From: Michael Eastham
Sent: 04 October 2017 11:08
To: Planning.Responses
Subject: FW: LU/278/17/RES - Construction of the southern section of the Lyminster Bypass

App No: LU/278/17/RES

Address: North Littlehampton Strategic Development Site Land West of Toddington Park,
Toddington Lane Littlehampton BN17 7PP

Proposal: Approval of Reserved Matters following Outline Permission LU/47/11 for
Construction of the southern section of the Lyminster Bypass, including northern
and southern roundabouts, surface water drainage and landscaping. Departure
from the Development Plan & affects a Public Right of Way.

Landscape Proposals SLB1
1 of 2

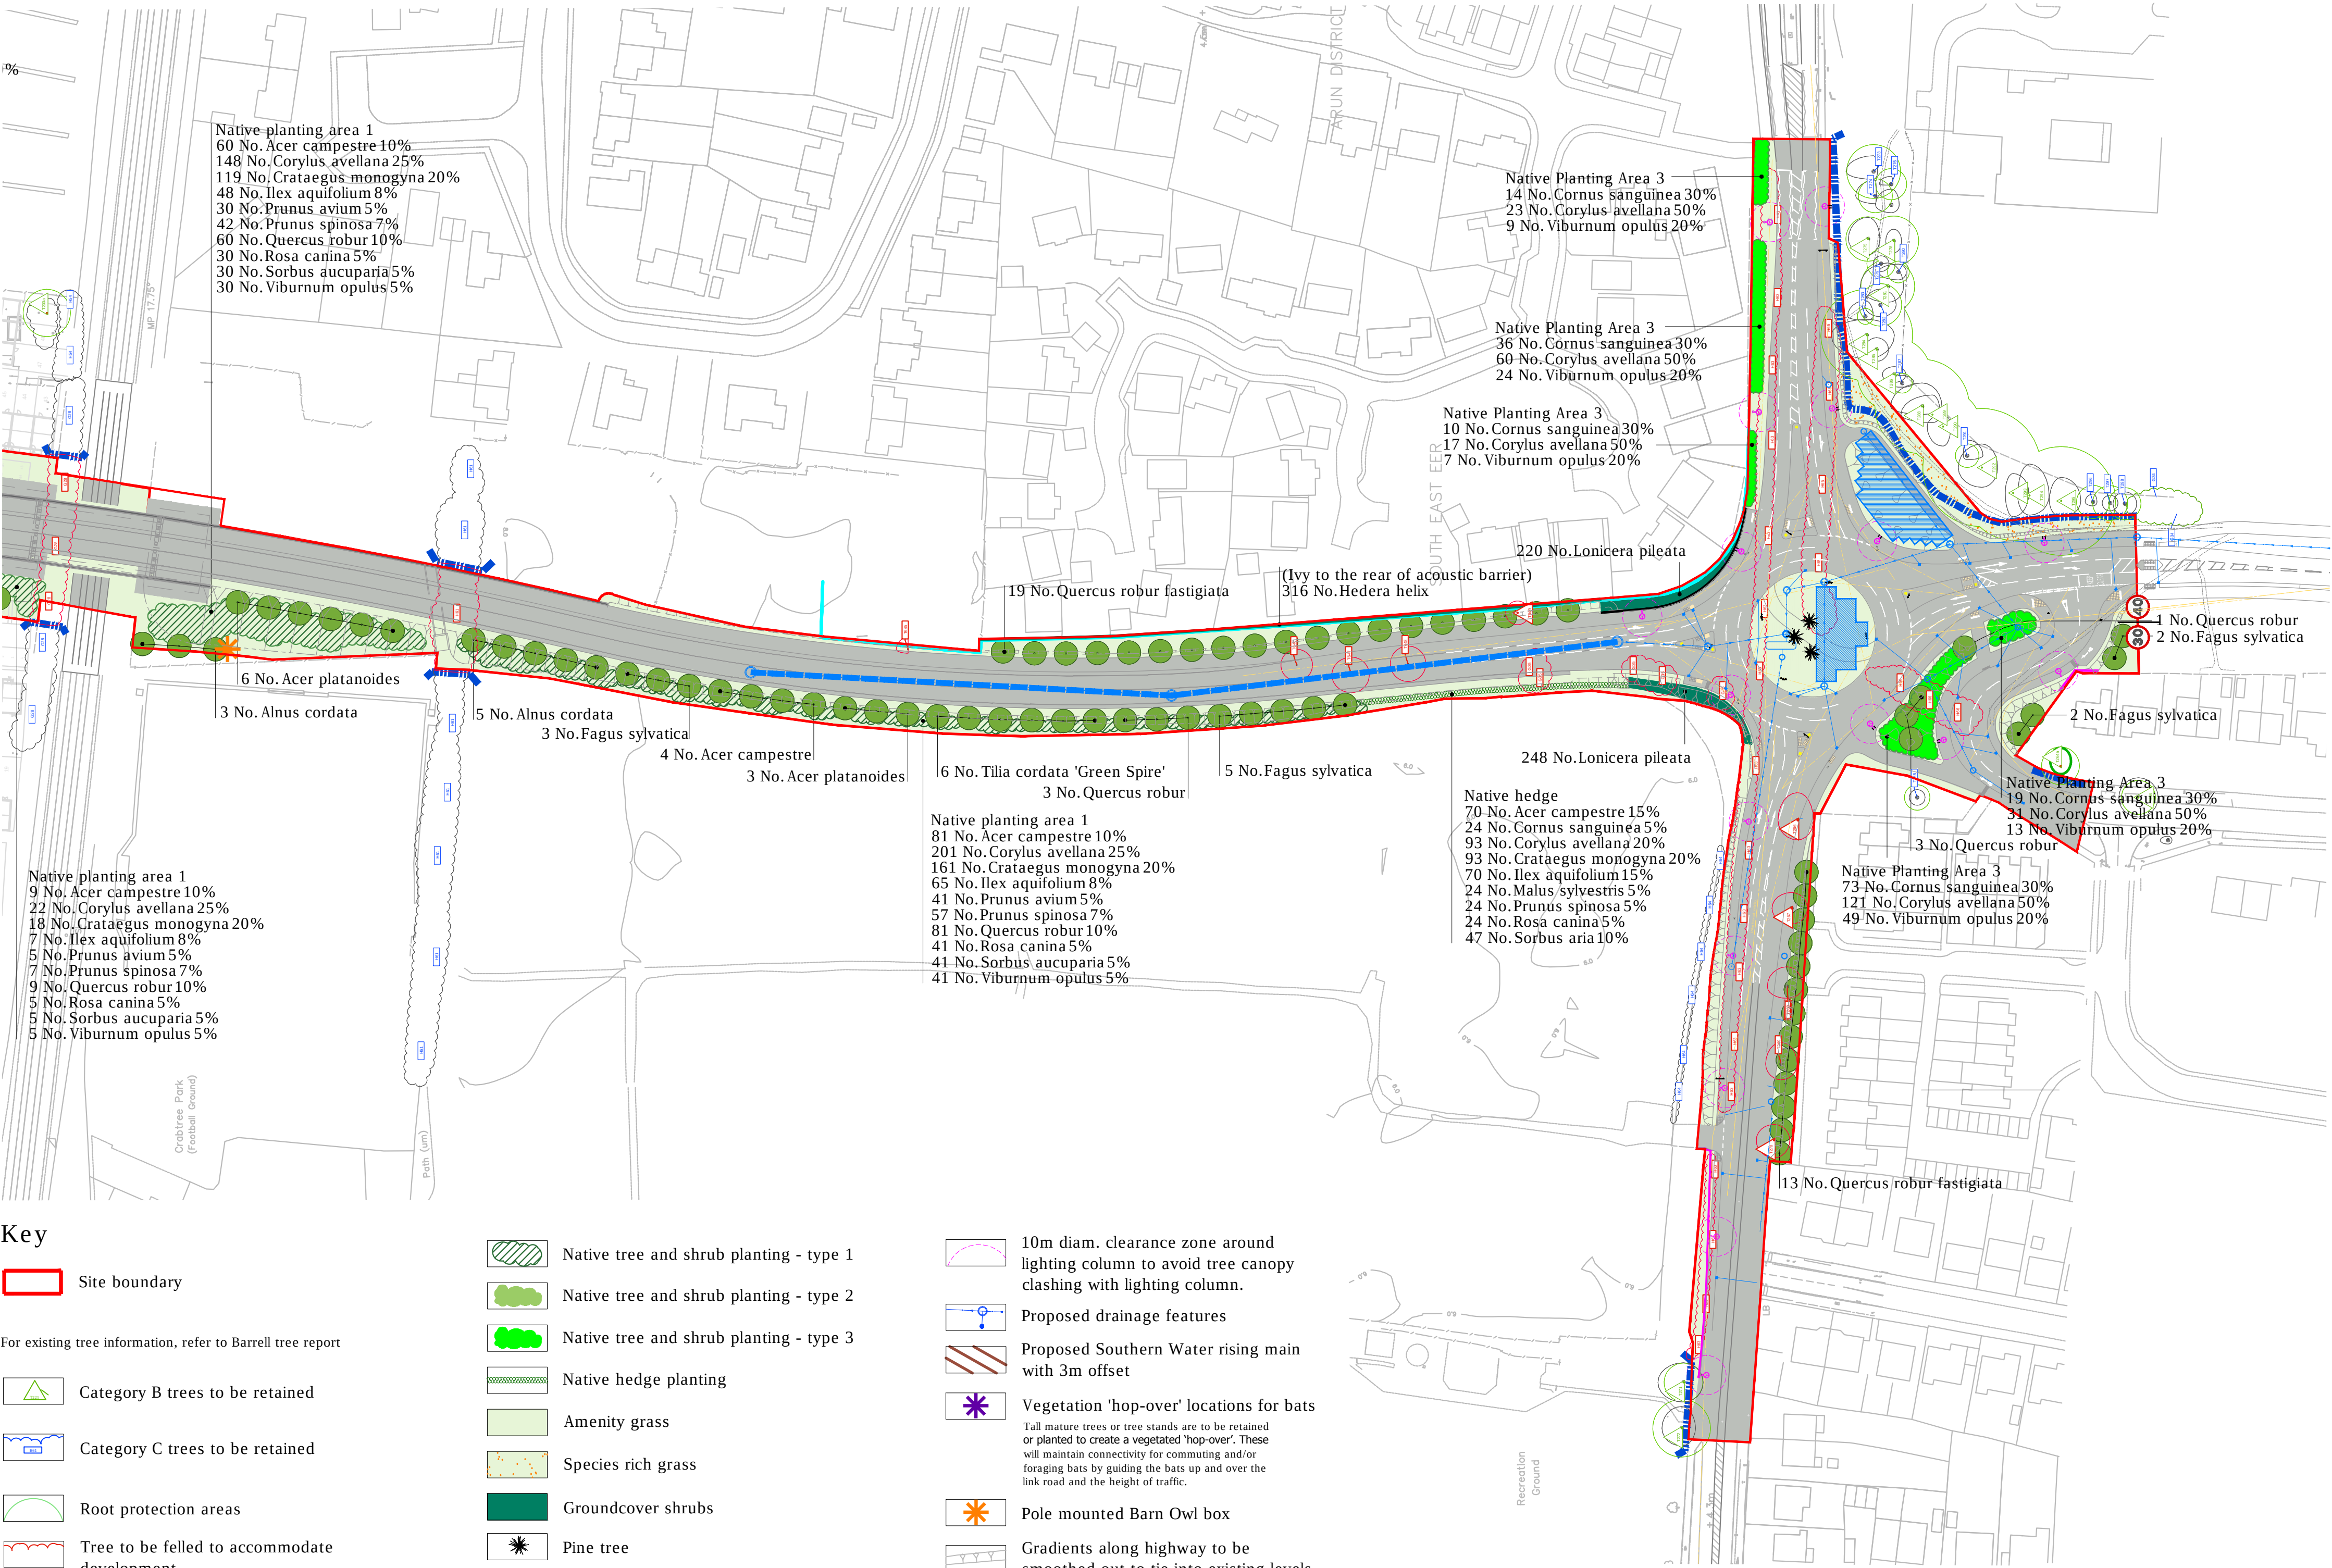
The lighting scheme for the site will need to take into consideration the presence of bats in the local area and the scheme should minimise potential impacts to any bats using the trees, hedgerows and buildings by avoiding unnecessary artificial light spill through the use of directional light sources and shielding.
